DRB Application No.: 08DRB-70293 Project # 1007304
Project Name: SPRINGER TRANSFER COMPANY ADDITION UNIT 1
Agent: WAYJOHN SURVEYING INC. Phone No.: 255-2052

**CITY OF ALBUQUERQUE
PLANNING DEPARTMENT
July 9, 2008
DRB Comments**

RE: Blocks 1 & 2, Springer Transfer Company's Addition No. 1

SKETCH PLAT

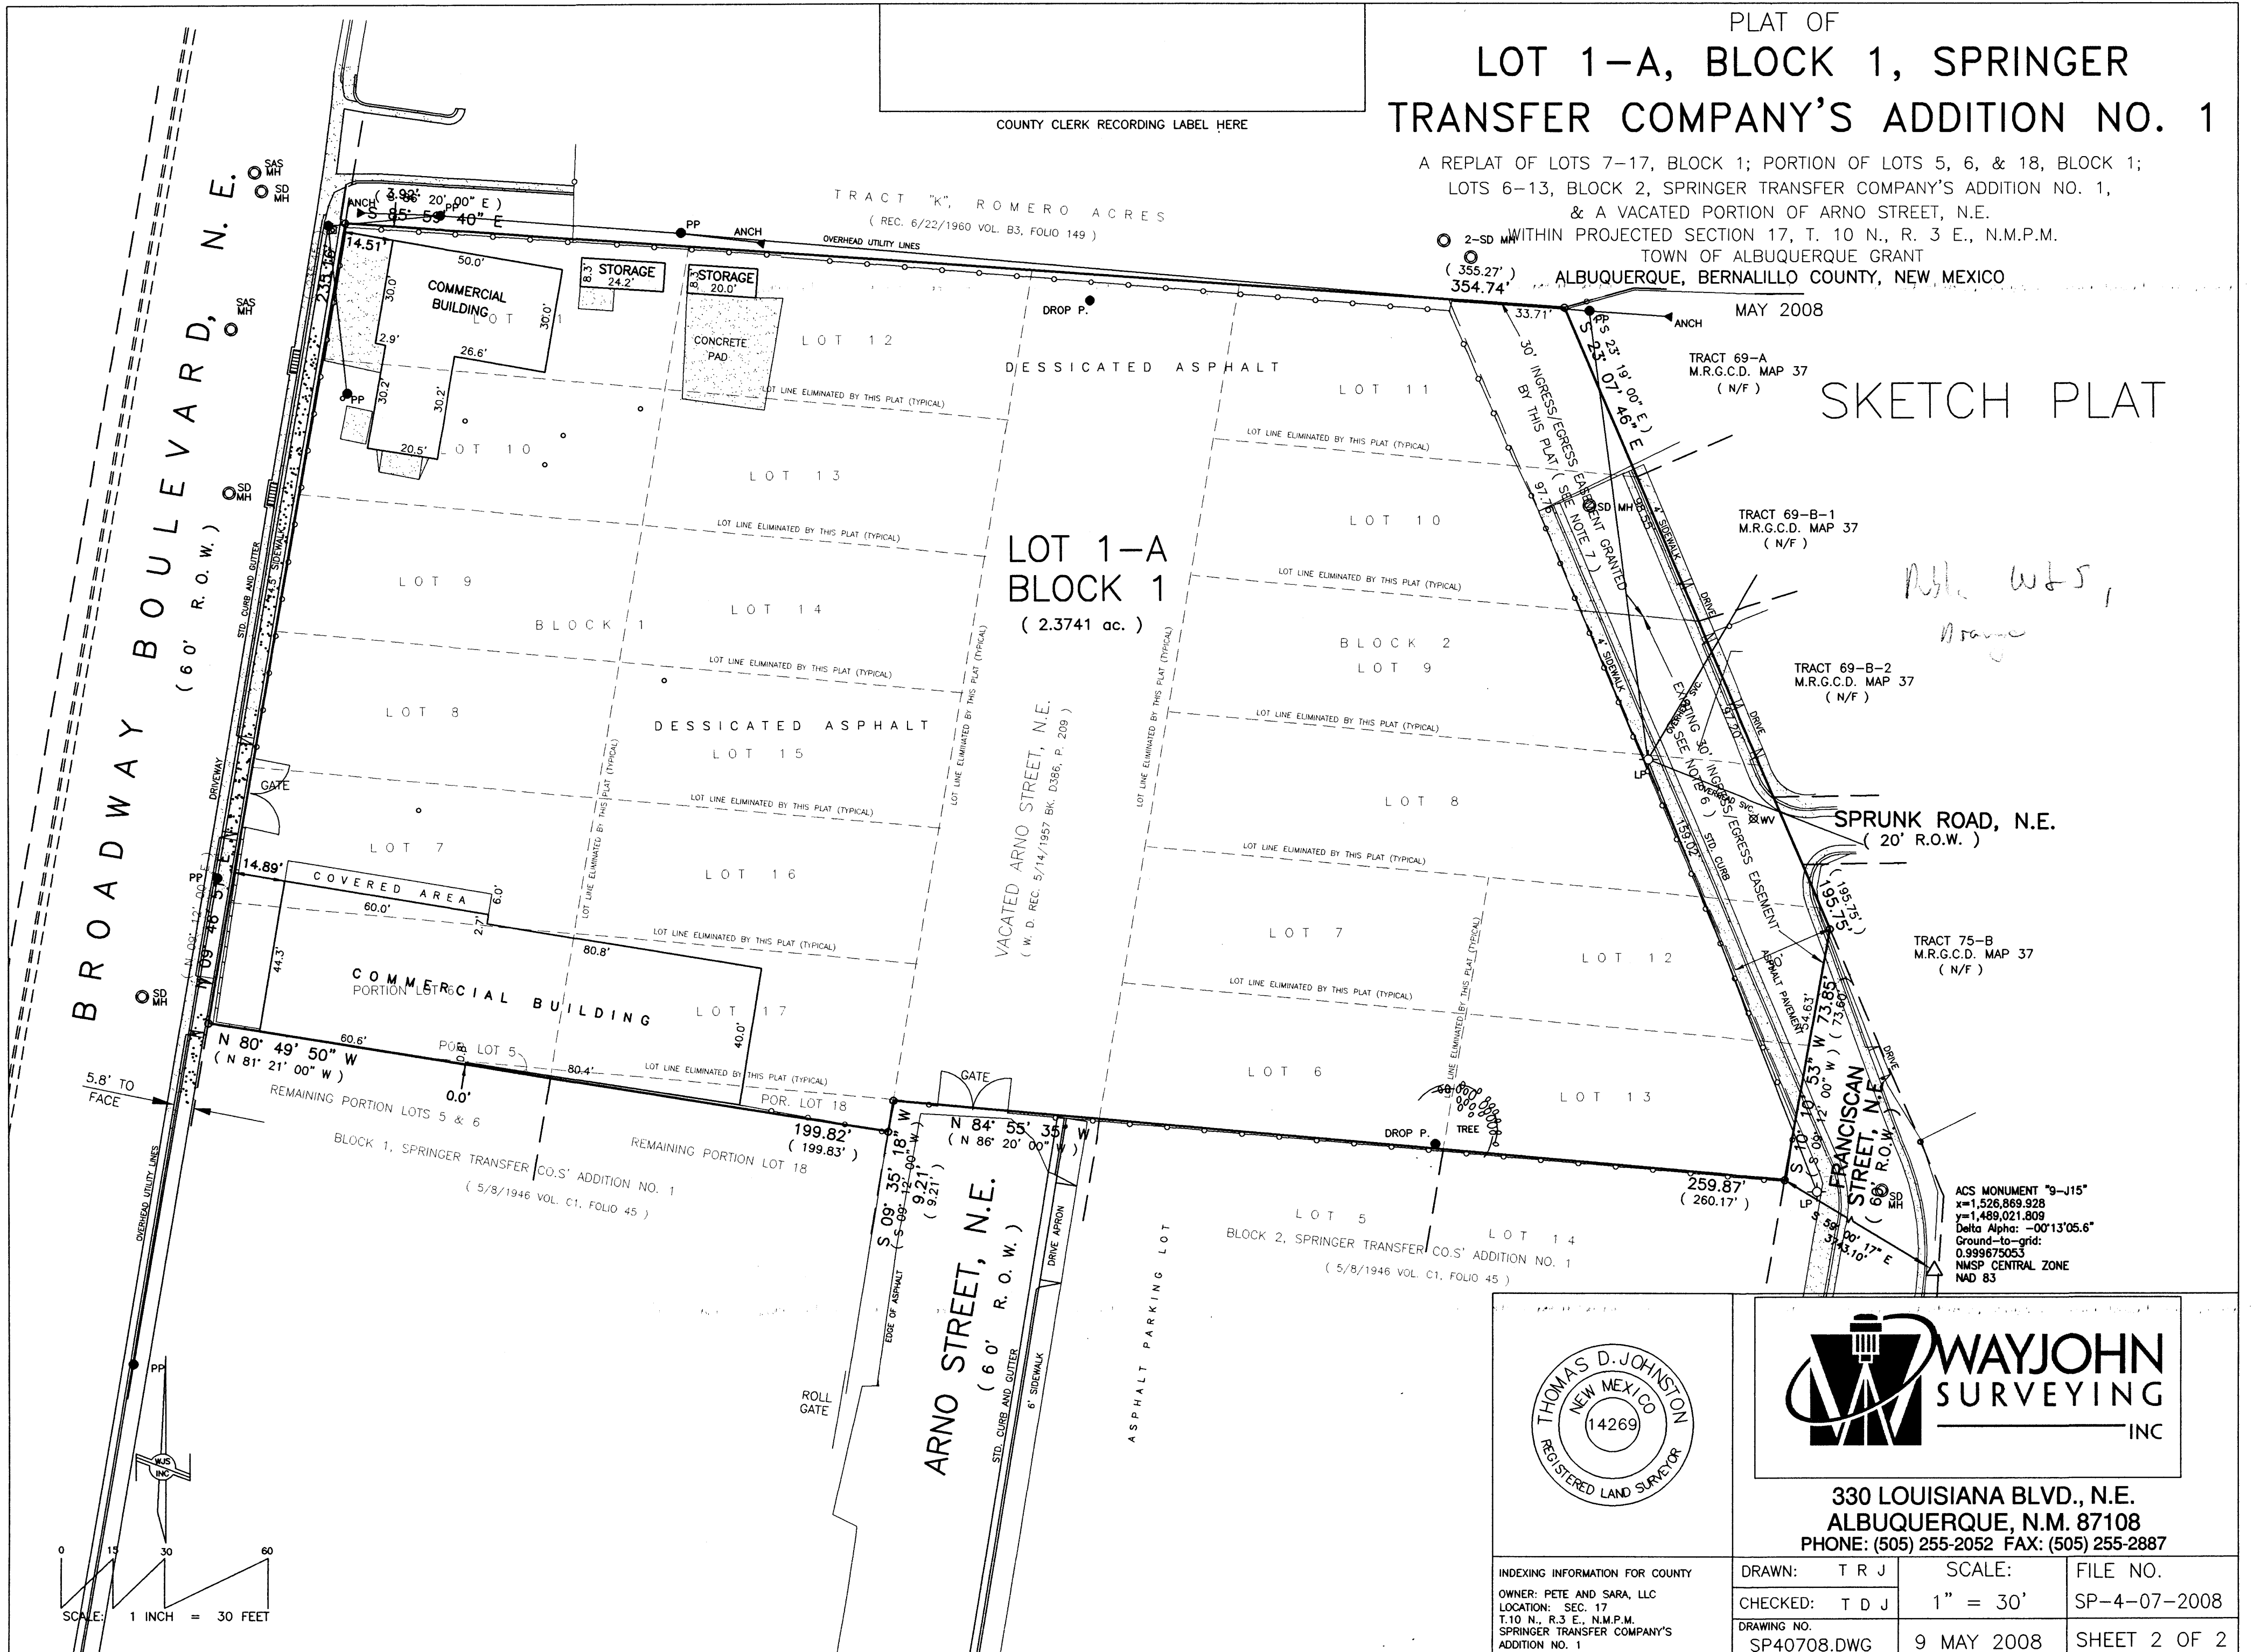
It appears turnarounds are needed for Arno Street and Franciscan Street.

The proposed Ingress/ Egress Easement should be granted for the benefit of the adjoining parcel (Tract K, Romero Acres) rather than the owner (the City); it appears that additional beneficiaries need to be identified.

Please use language in the solar collector note to be specific to this type of request, i.e. use the words "THIS PLAT" and not "REQUESTED FINAL ACTION" in the beginning of the note and delete the words "OR SITE DEVELOPMENT PLAN FOR SUBDIVISION" from the end of the note.

Need public subsurface drainage easement granted to City. Owner should be maintaining the surface of this easement.

EXISTING  
 CONDITIONS

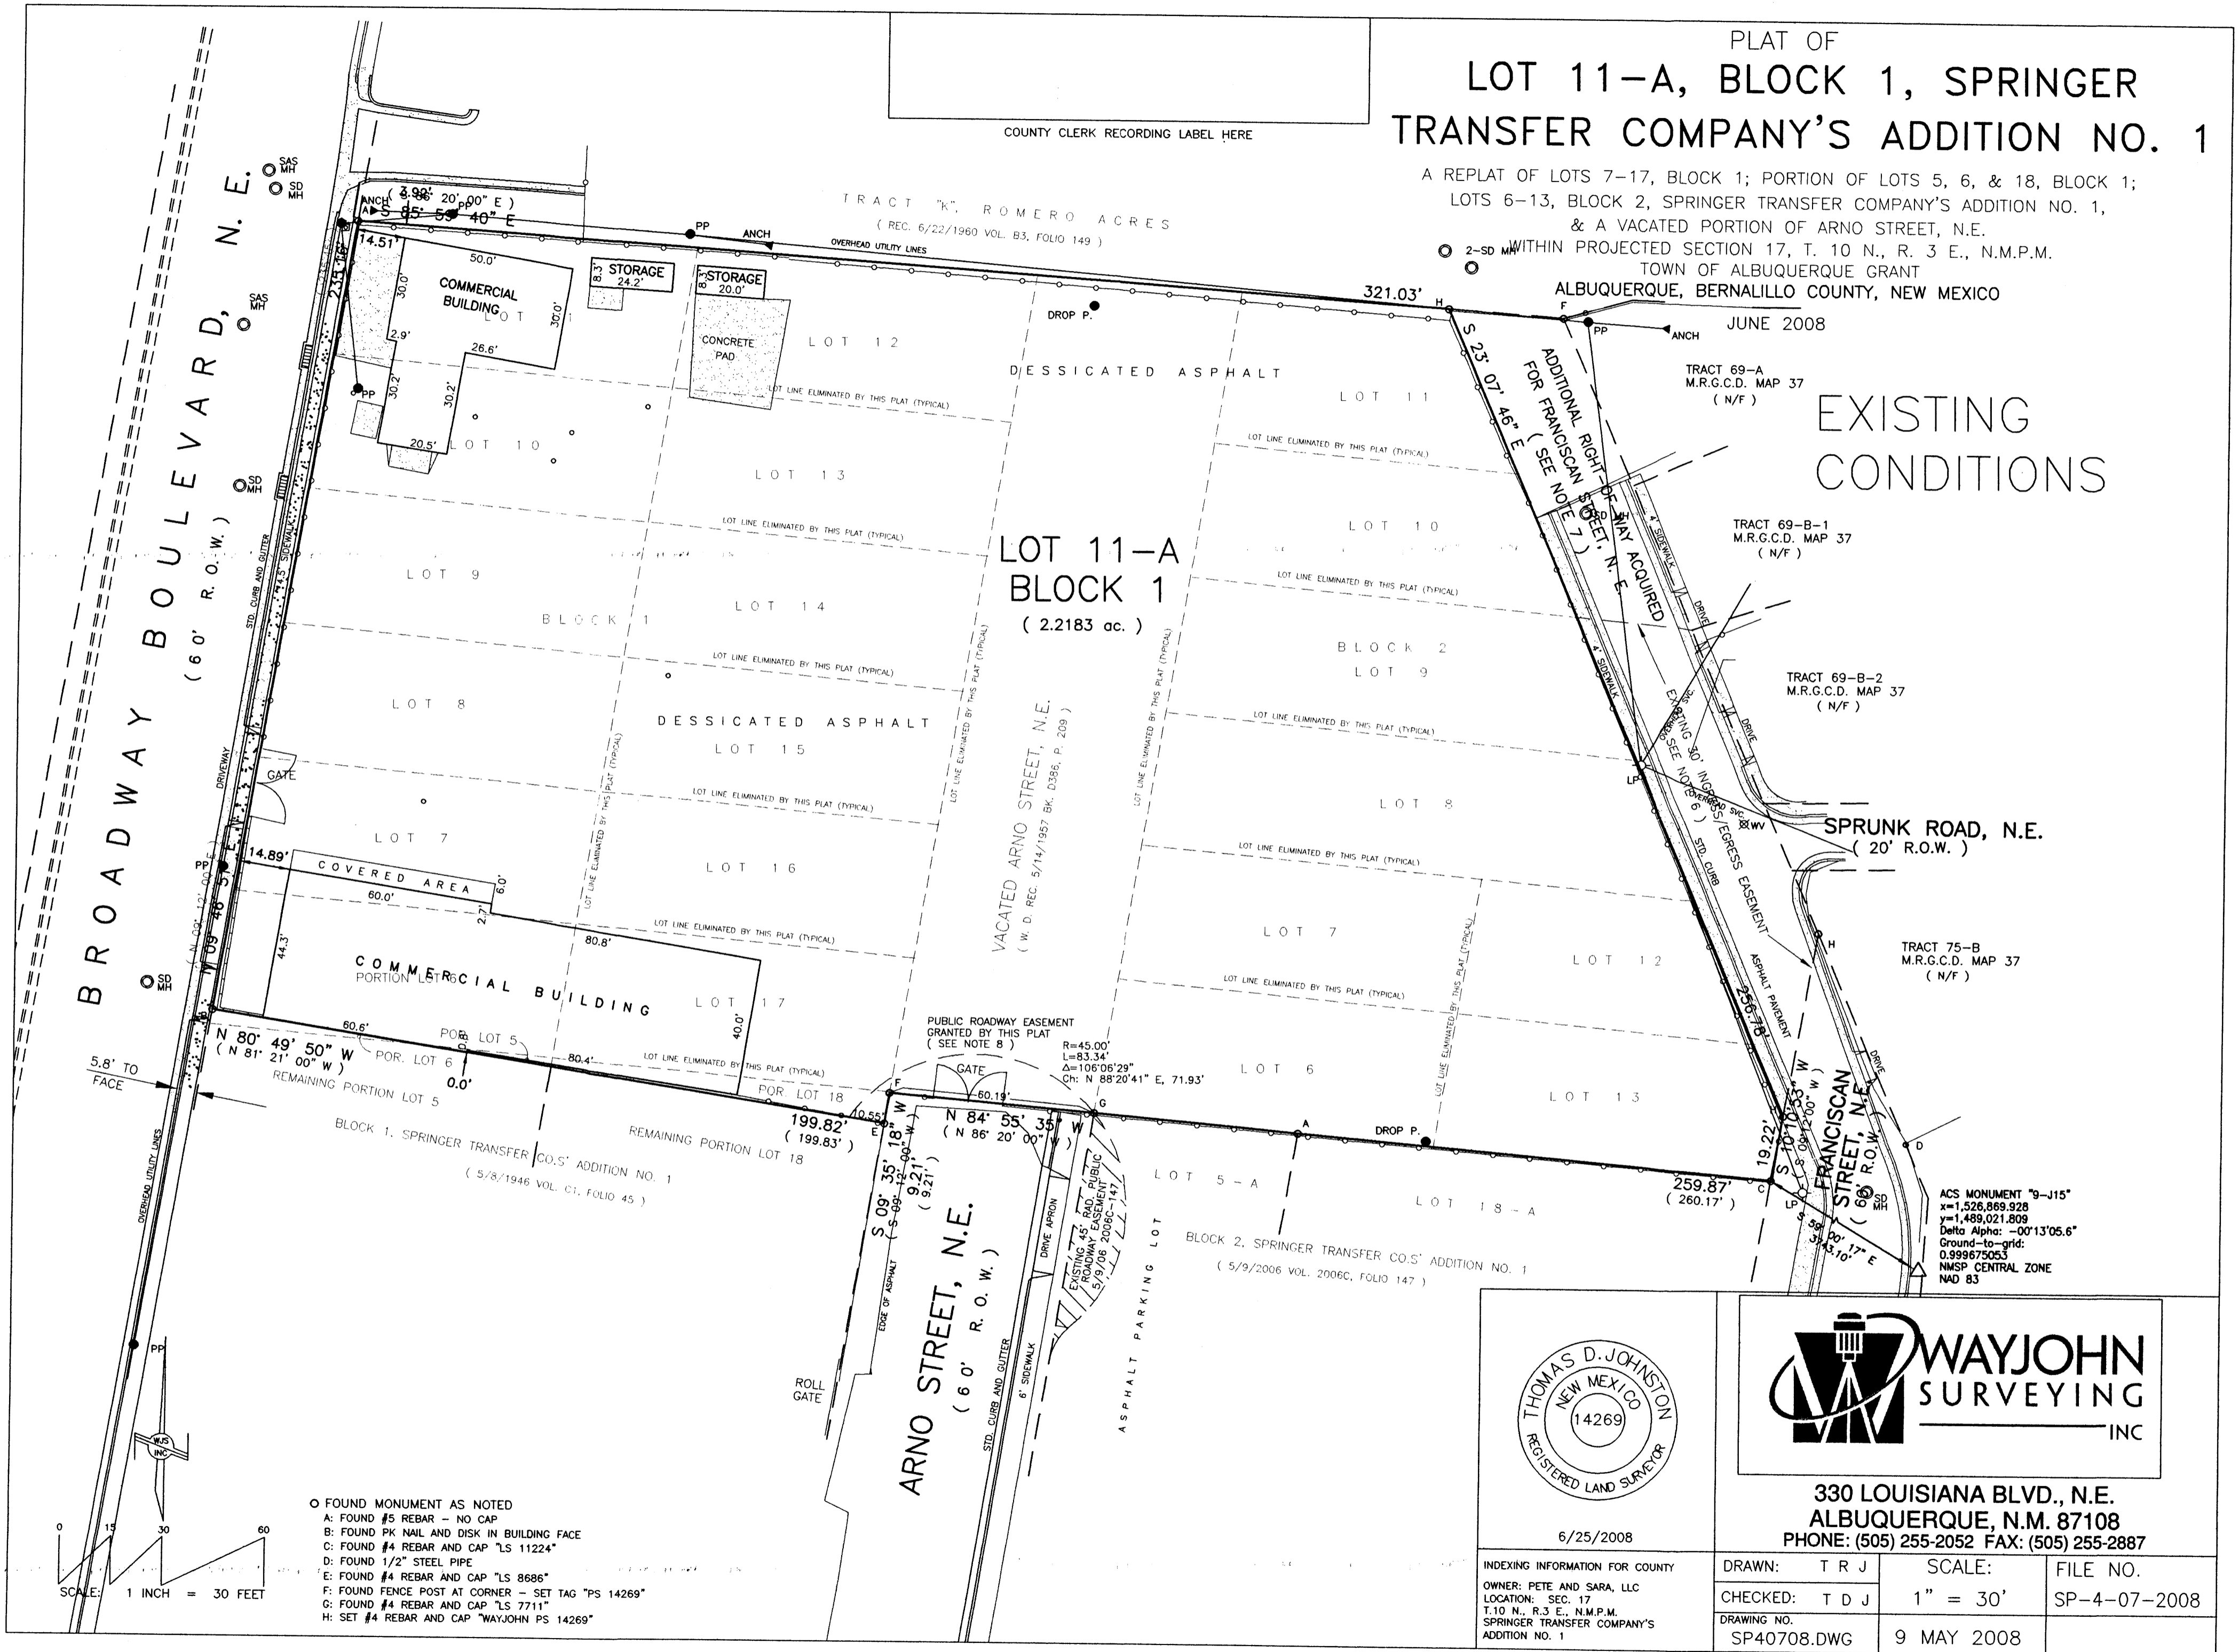
It appears a public turnaround may be needed for Franciscan Street.

Please use language in the solar collector note (No. 4) to be specific to this type of request, i.e. use the words "THIS PLAT" and not "REQUESTED FINAL ACTION" in the beginning of the note and delete the words "OR SITE DEVELOPMENT PLAN FOR SUBDIVISION" from the end of the note.
